October 8<sup>th</sup>, 2013

**RE: ZONING BY-LAW AMENDMENT  
2940 & 2946 BASELINE ROAD (FILE #D02-02-12-0077)  
PLANNING RATIONALE ADDENDUM AND RESPONSE TO TECHNICAL COMMENTS**

Front Elevation
Scale 1:250

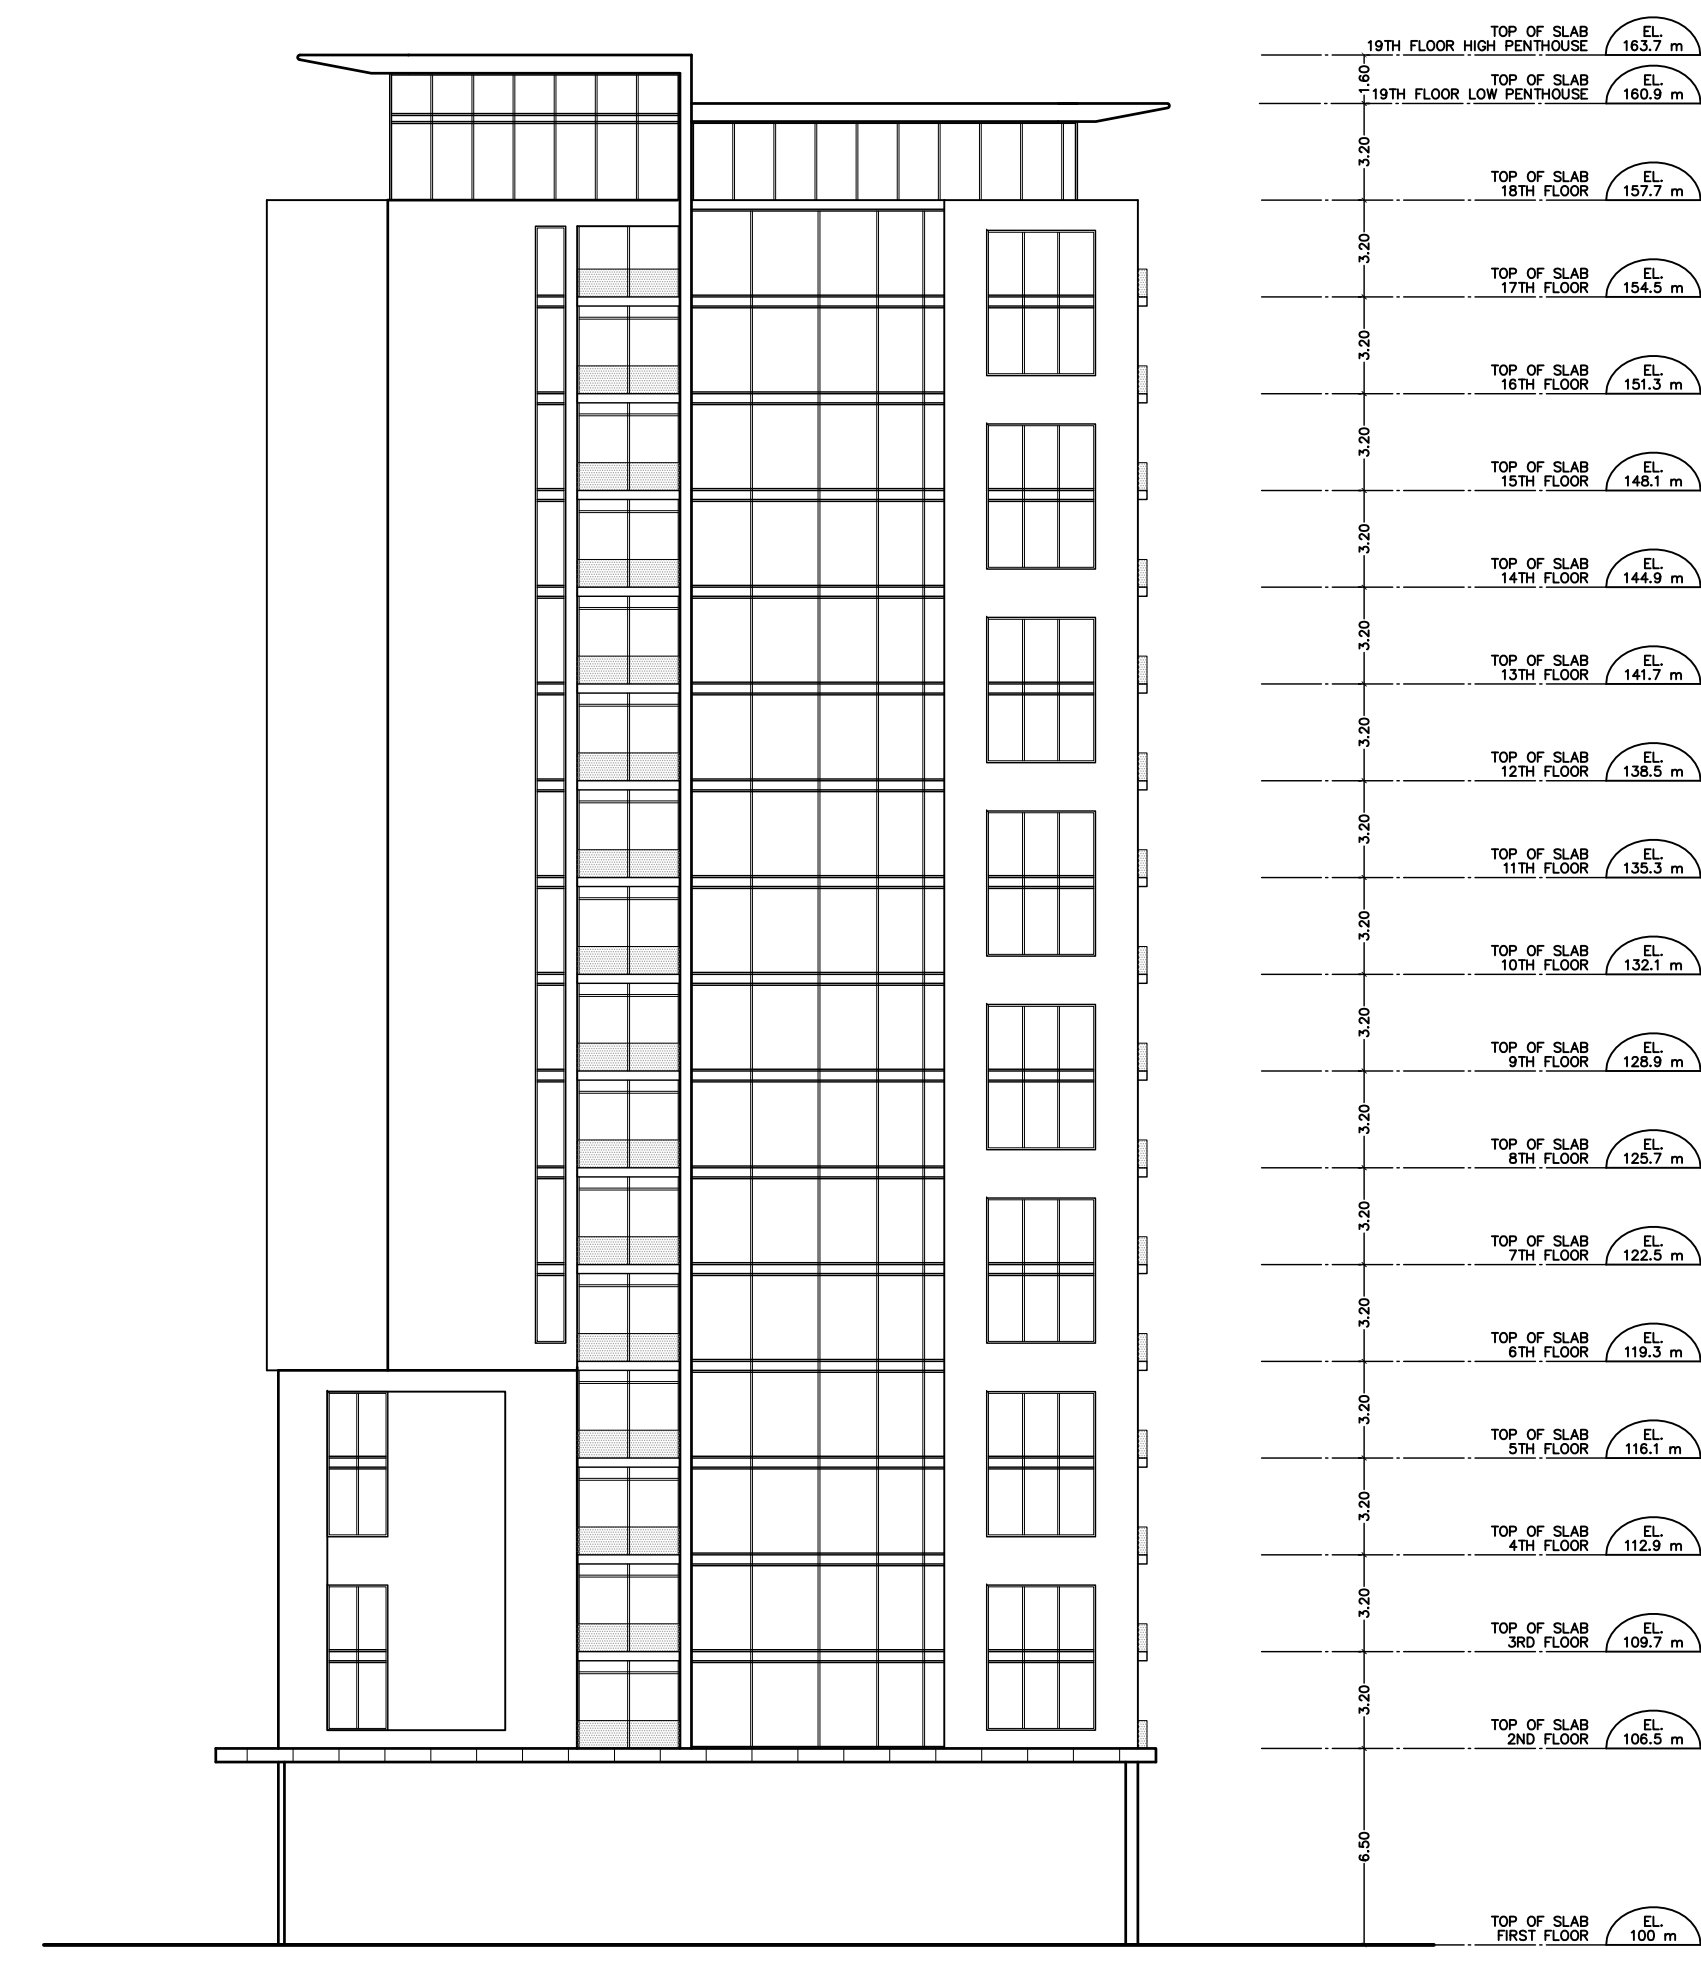
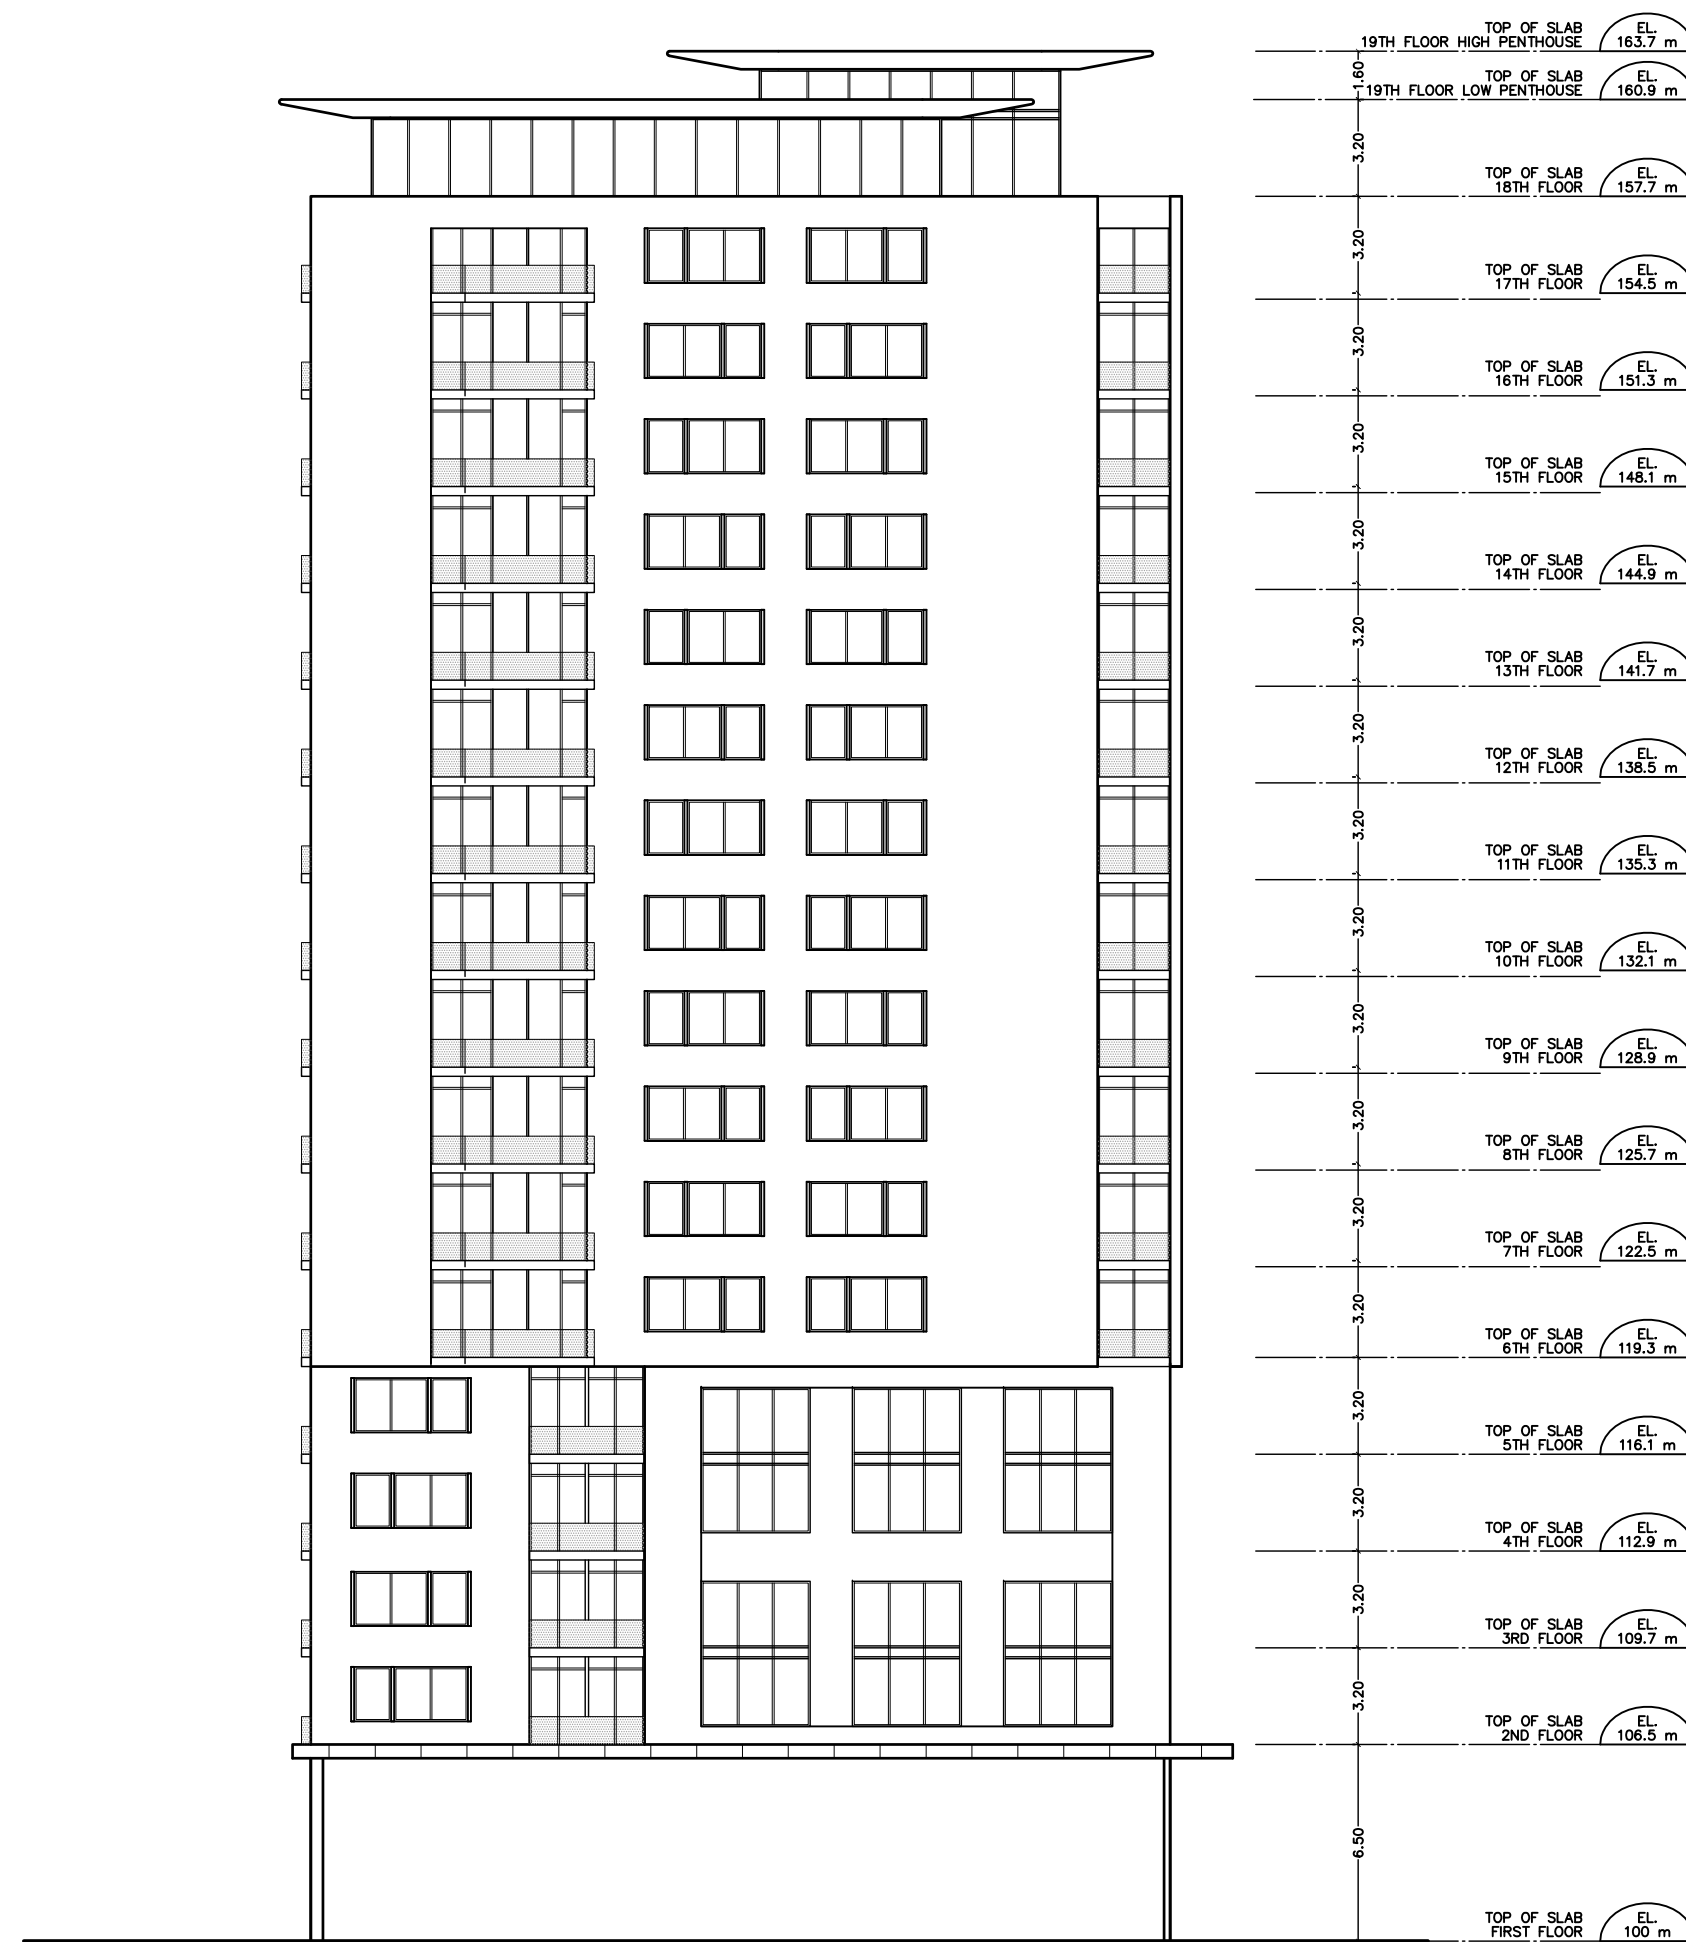
- The effect on the skyline of the design of the top of the building is not addressed.

- Architectural design (e.g. the use of angular planes, cornice lines) – There is a lack of information regarding the design of the bases or podiums.

- The top of the building is designed with a sloped roof to add visual interest, the eastern halves of which are grated to ensure views and allow sunlight to pass through. Generous glazing at the upper levels of the buildings will reduce visual impacts, and trees on the amenity spaces will also be visible from a distance. The roofs will be visible from all directions.

- NEUF, the project architect, will provide colour renderings and elevations, to better understand the proposed architecture. In the interim, please refer to Perspectives drawings in the submission package.
